CITY OF ALBUQUERQUE

September 17, 2014

**Re: Trapnell Orthodontics
Conceptual Grading and Drainage Plan
No Engineer's Date (J09D022)**

CG-101

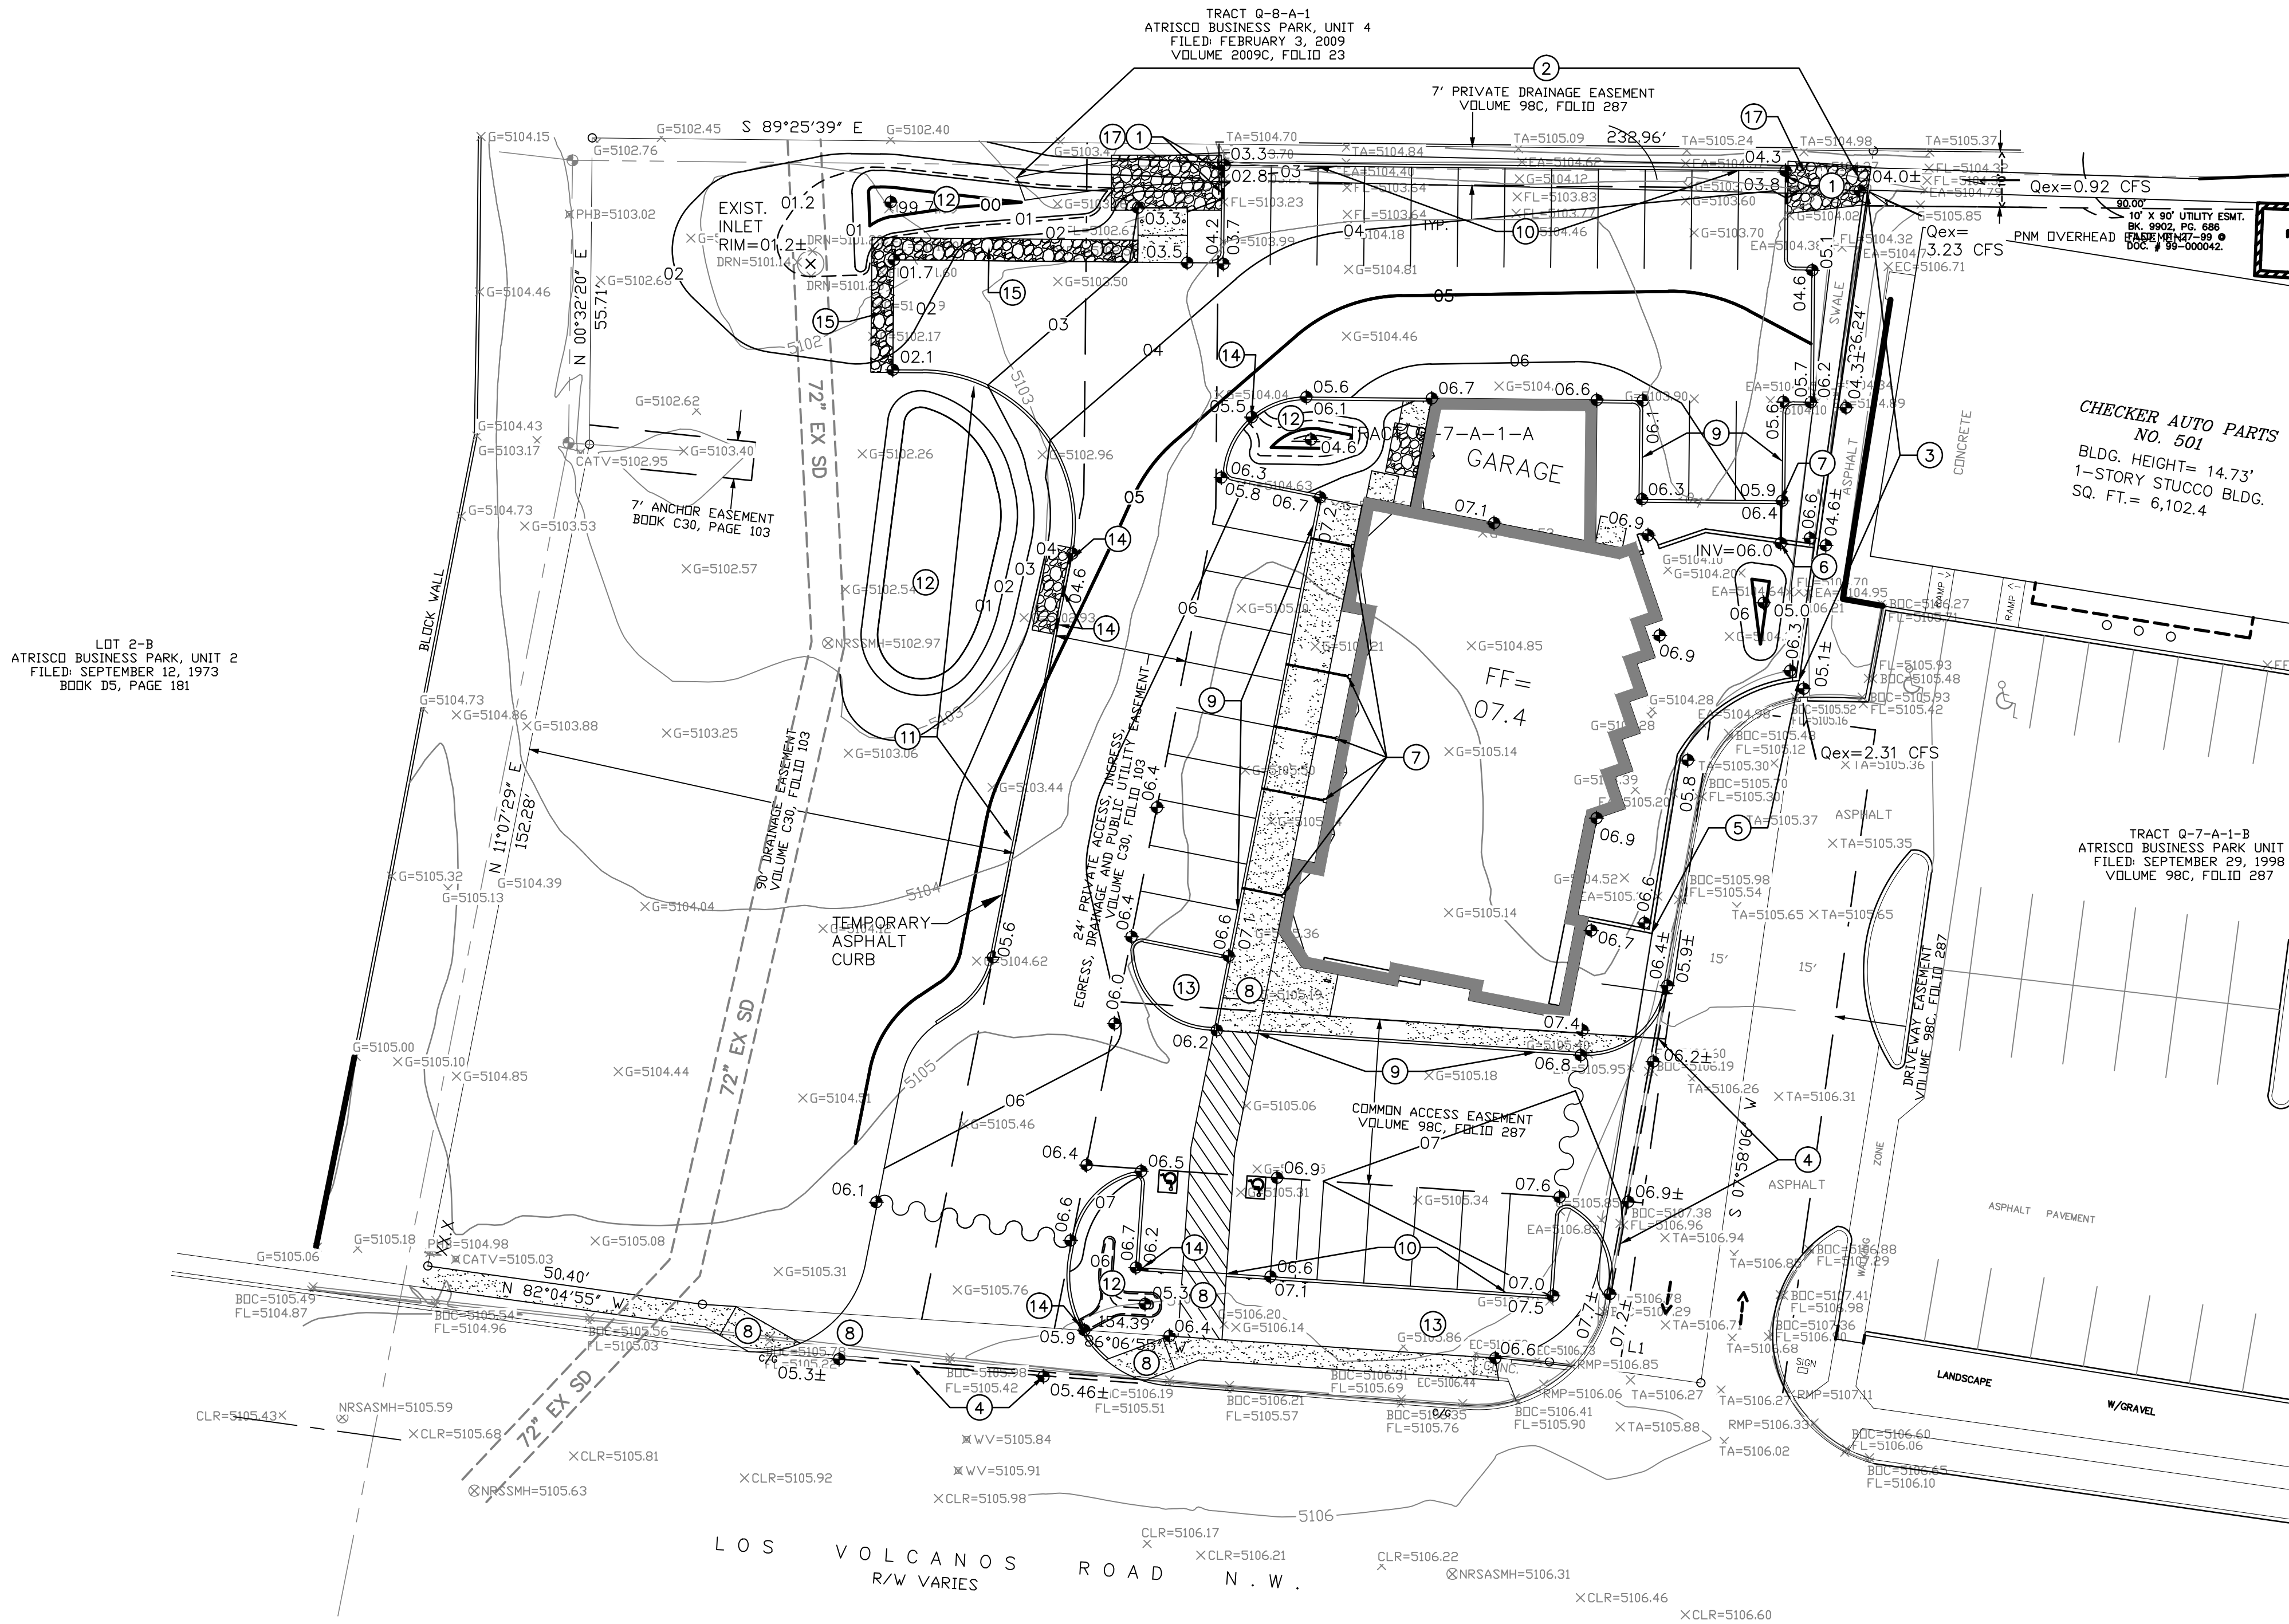
1. Shorten the driveway leading to the inlet approximately ten feet. This is to allow sufficient room for riprap and energy dissipation of the drainage prior to entering the inlet. It is expected that the grate of the inlet will be higher than the bottom of the pond for the design of the First Flush. Provide a revised Grading and Drainage Plan and revised Site Plan that have matching layouts as a result of the redesign.
